## 415 Cumberland Ave.

**Christian Roadman** <croadman@portlandmaine.gov>

Per our conversation yesterday, attached are two diagrams detailing 1) necessary sidewalk repairs and 2) proposed window changes.

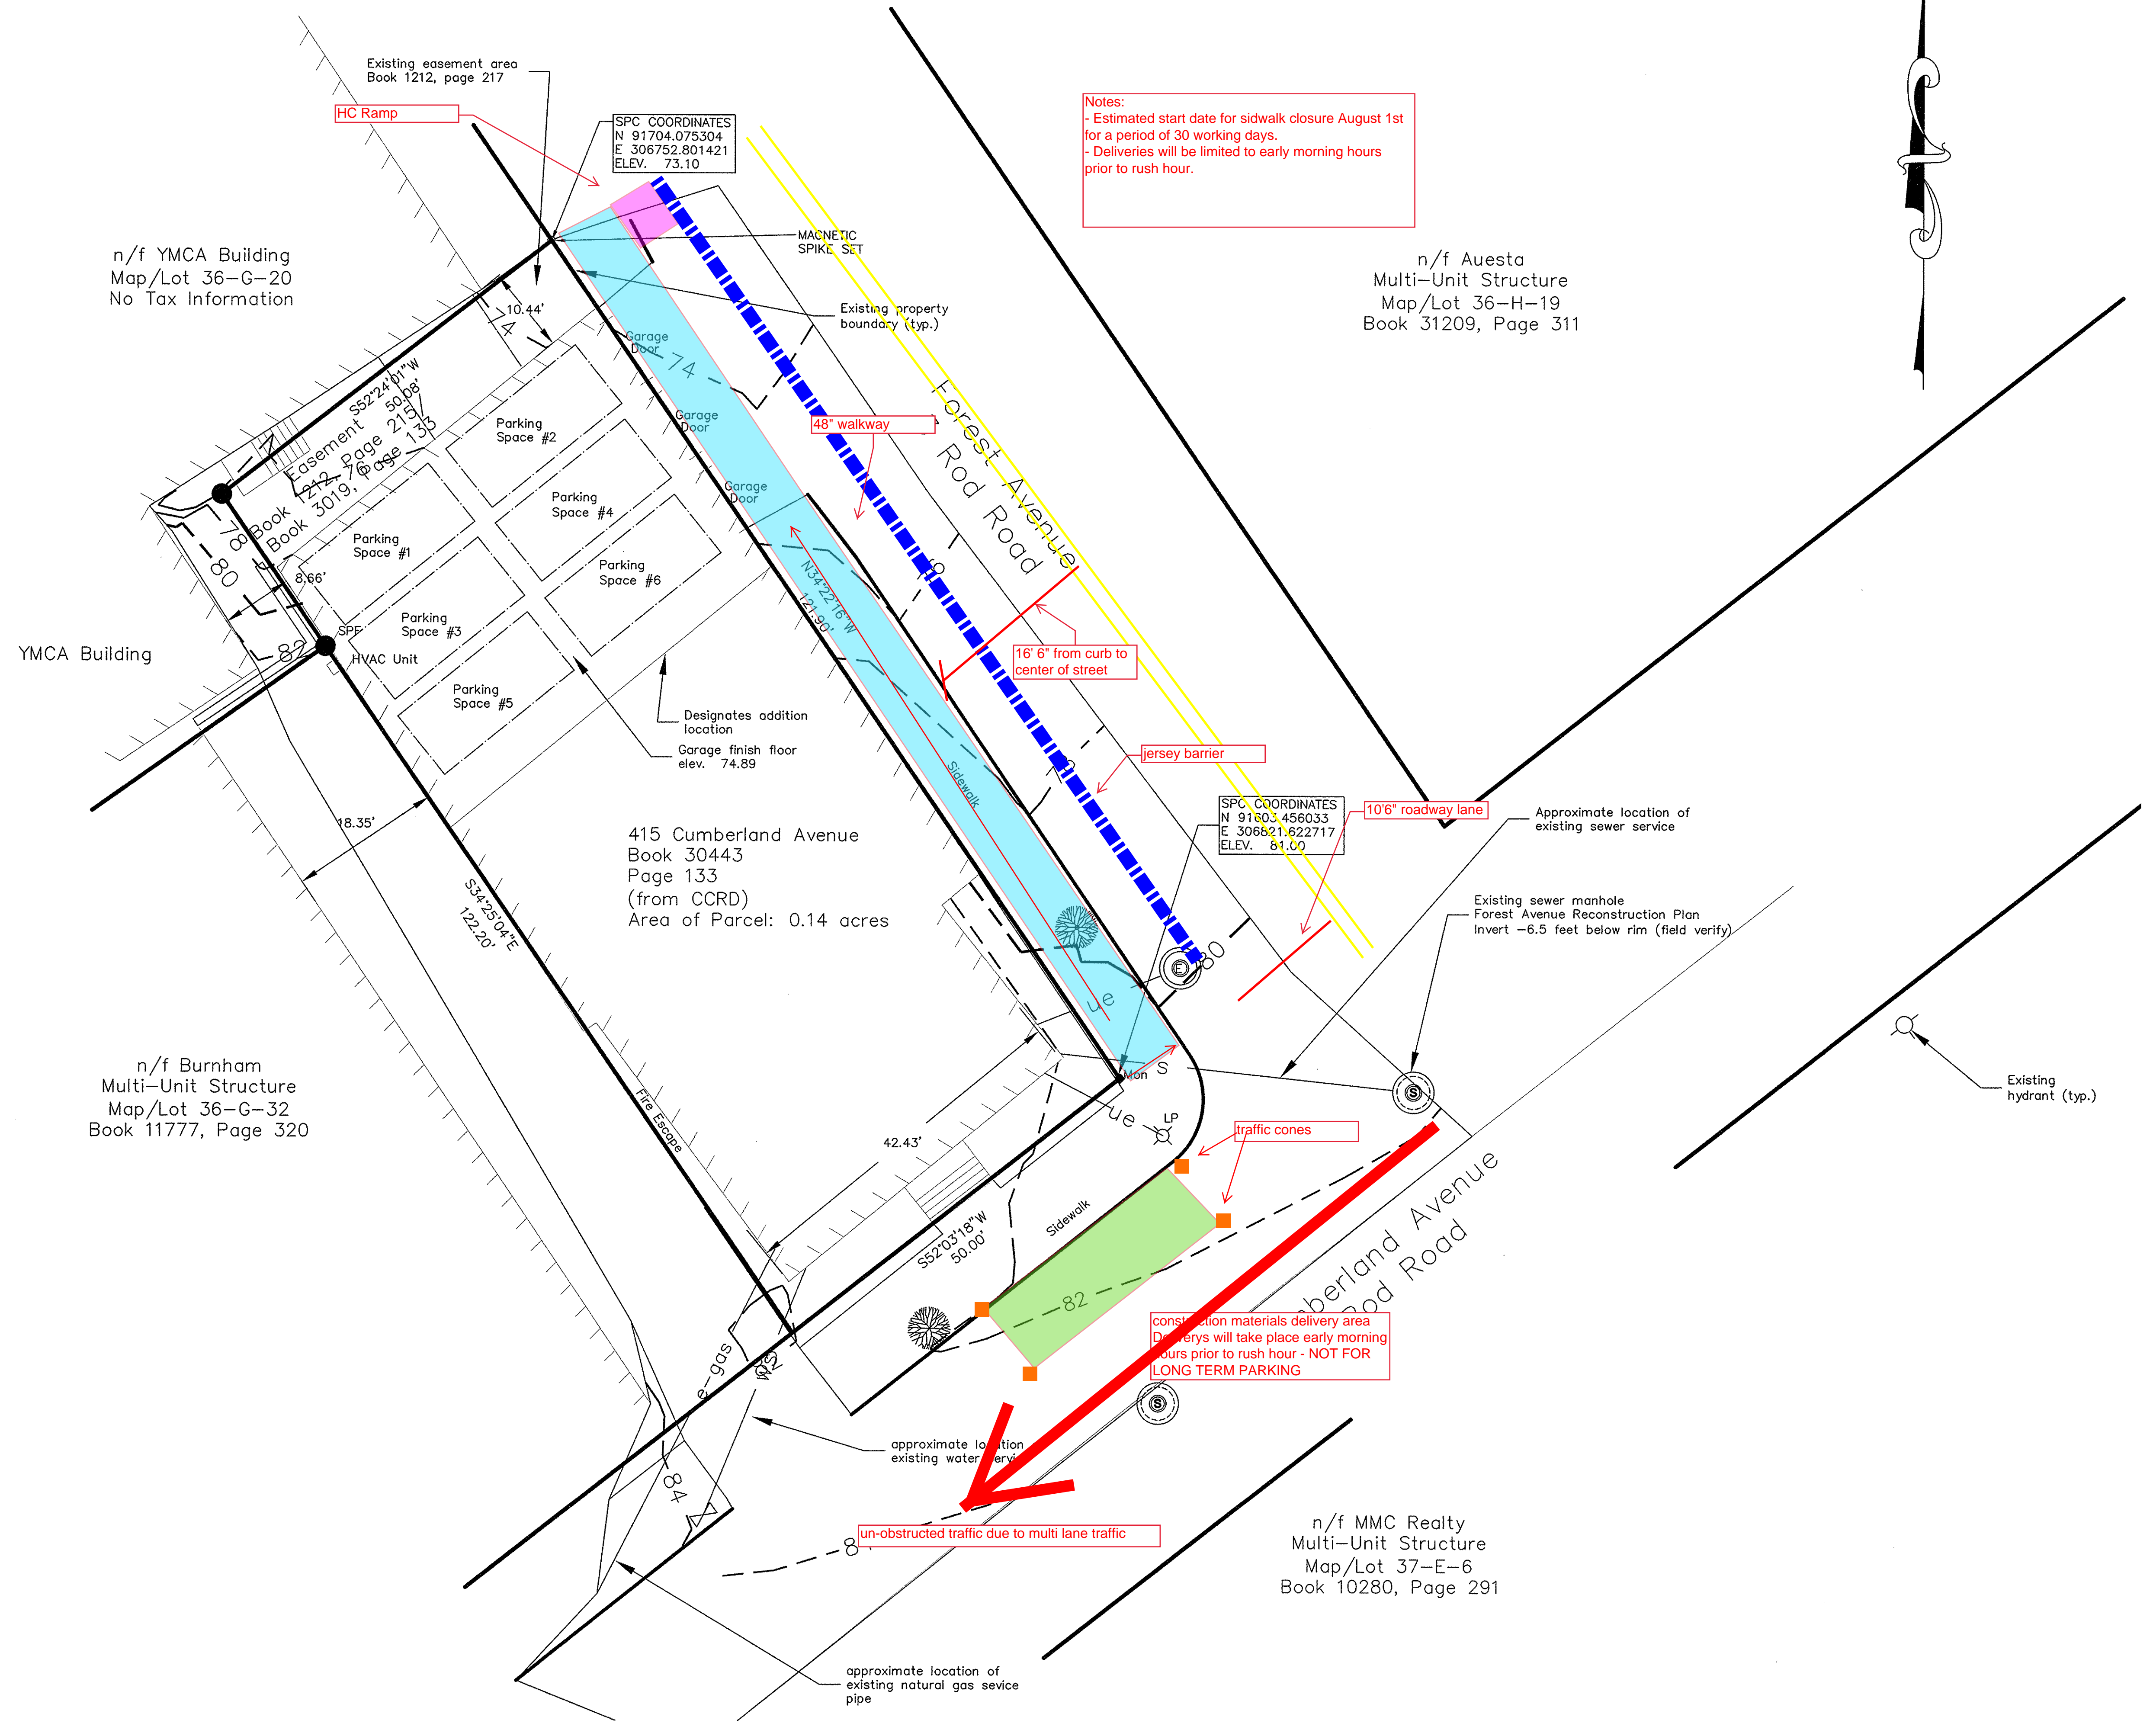
Also per our conversation yesterday: the submitted construction management plan only includes the written portion, and doesn't include a physical plan that shows the pedestrian / delivery / traffic routes. Without such a plan I'm afraid the relevant condition can't really be met.
